February 2016

Addendum to Technical Support Document #3

**AIR QUALITY & ODOUR ASSESSMENT**

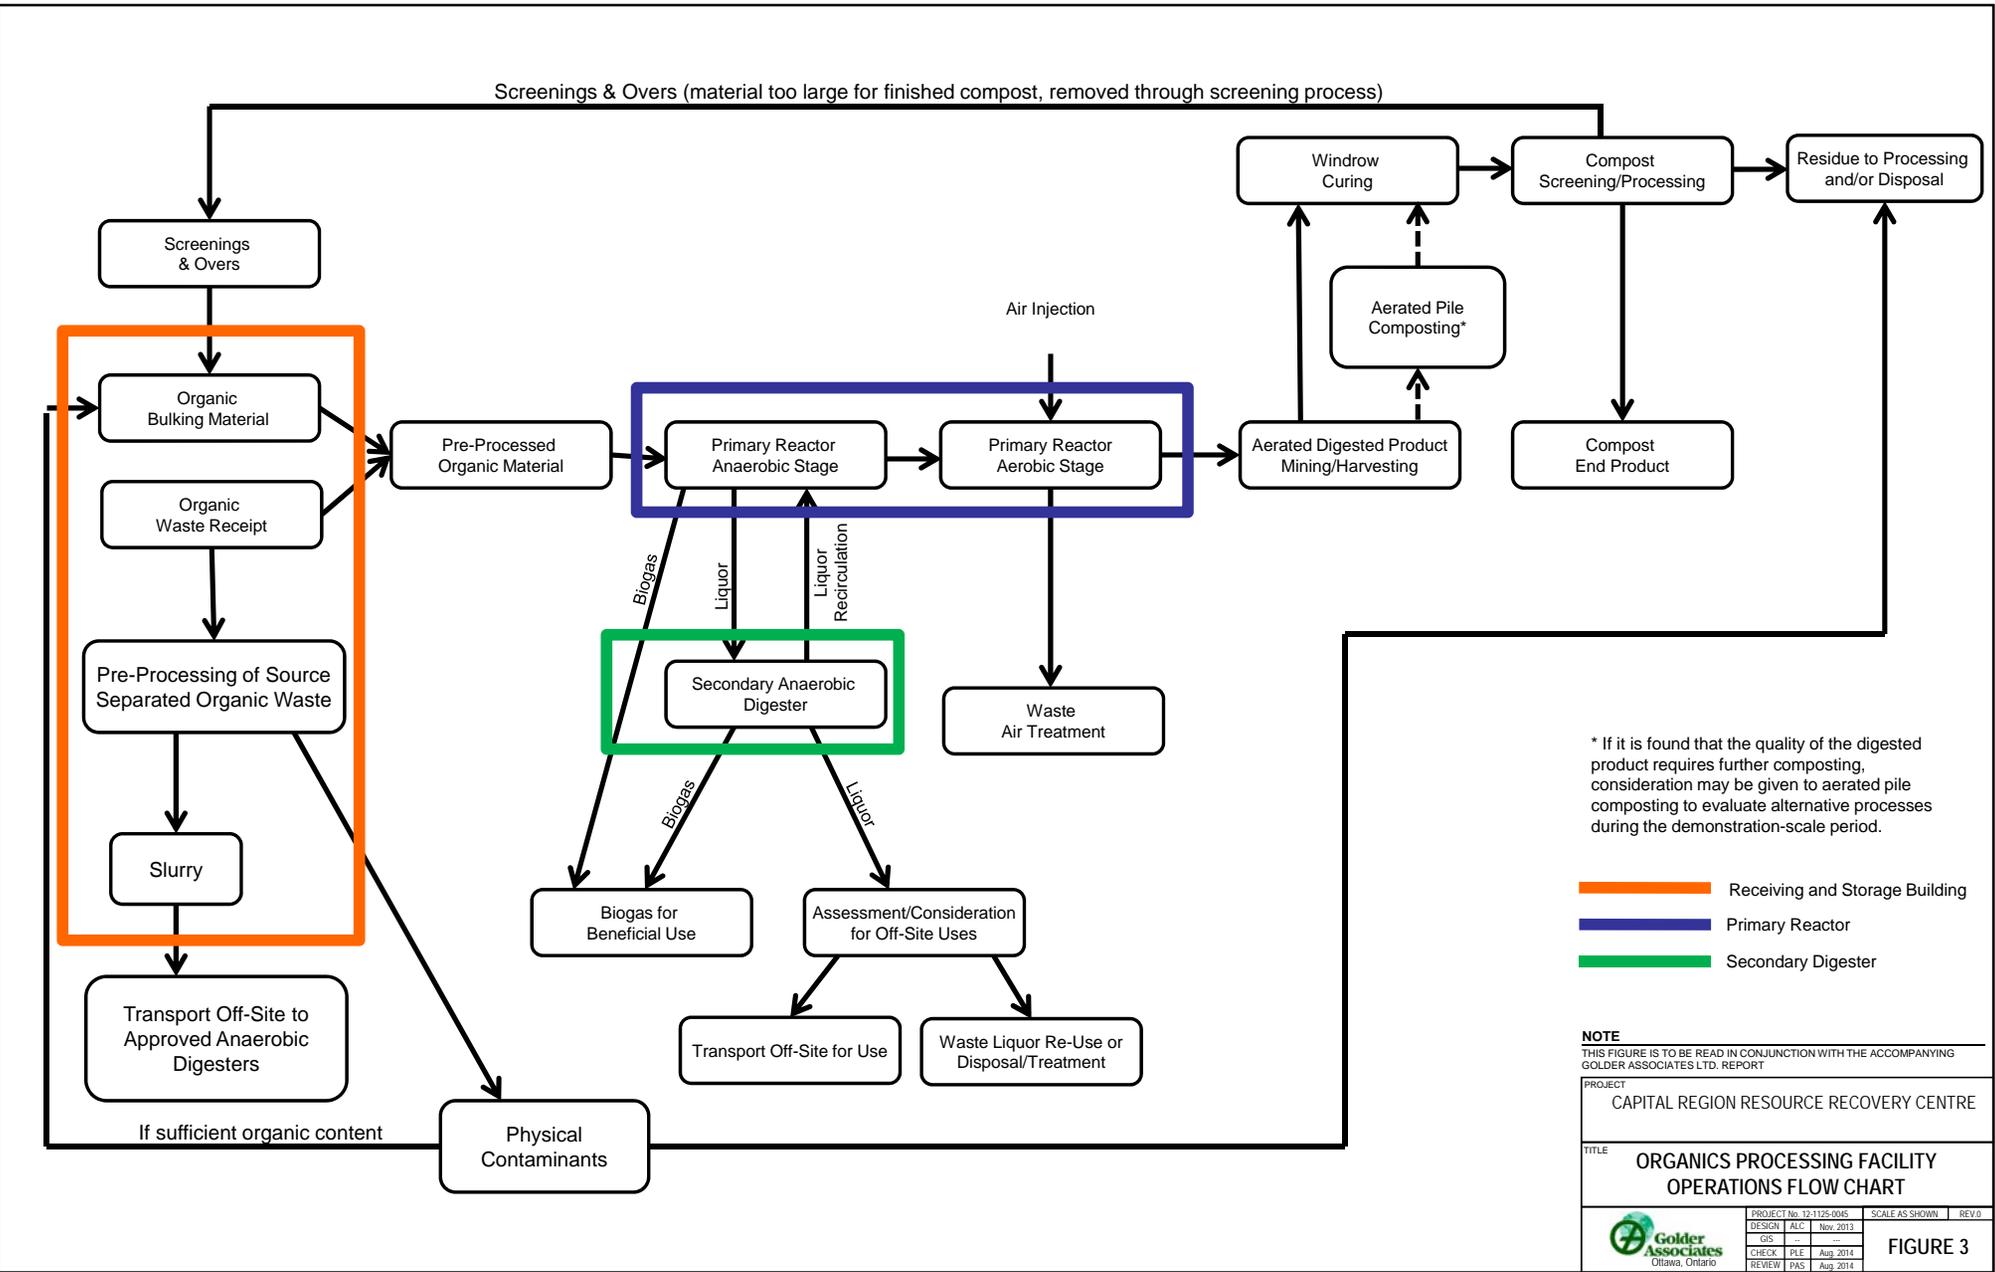
- Comments 6-9 & 19: Additional information with respect to potential odorous sources related to the loading and unloading of the organics processing primary reactor cells and overall material handling of potentially odorous organic material.

Comments 7, 8, 9 & 19 are mainly addressed in the updated odour management plan memo contained in Appendix A of this addendum. To complete the response to comment 19, a primary reactor odour source was added at the organics processing facility location. For odour modelling purposes, 5% of the size of the landfill odour source area was used as the primary reactor odour source area. The rationale for the use of 5% is described below.

The organics processing is to take in 50,000 tonnes per year; at 312 operating days/year, this equates to 160 tonnes/day. The organics mixed with bulking agent will be moved and placed in the primary reactor cell during the latter part of each operating day at a rate of about 70 tonnes/hr. It has been assumed that the “latter part of the day” is 3 to 4 hours out of the 12 hour day, which means that 210 to 280 tonnes/working day of organics mixed with bulking agent is moved and placed in the primary reactor. This is the material that represents the odour source for the modelling. It was also assumed that the weight of wet food waste is approximately 1 tonne/cubic metre, which corresponds to 210 to 280 cubic metres per day of airspace in the primary reactor. Each primary reactor cell is 70 metres wide x 300 metres long in plan area.

The primary reactors have been designed with a triangular cross-section, as per Appendix G Figure 2 in Volume IV, of 70 metres across with 5.25H:1V slopes to a peak height of 7 metres. Every 1 metre length of the reactor corresponds to a volume of 245 cubic metres, or about 1 day’s placement. Because it would be impractical to build the cell in 1 metre strips, it was assumed the mixed organics would be placed over roughly half the cell width (35 metres) to the final shape (volume of approximately 123 cubic metres/metre): this would require a cell length of about 1.7 to 2.3 metres, which is something that could be built with a loader, but more likely would be approximately 3 metres wide. As such, the available daily quantity would not enable the cell to be built to its final shape in a single day. At 3 metres wide, the corresponding footprint area (odour source area) would be about 90 square metres. Compared to the landfill working area odour source area of 1,500 square metres, this is about 6% of the landfill source area.
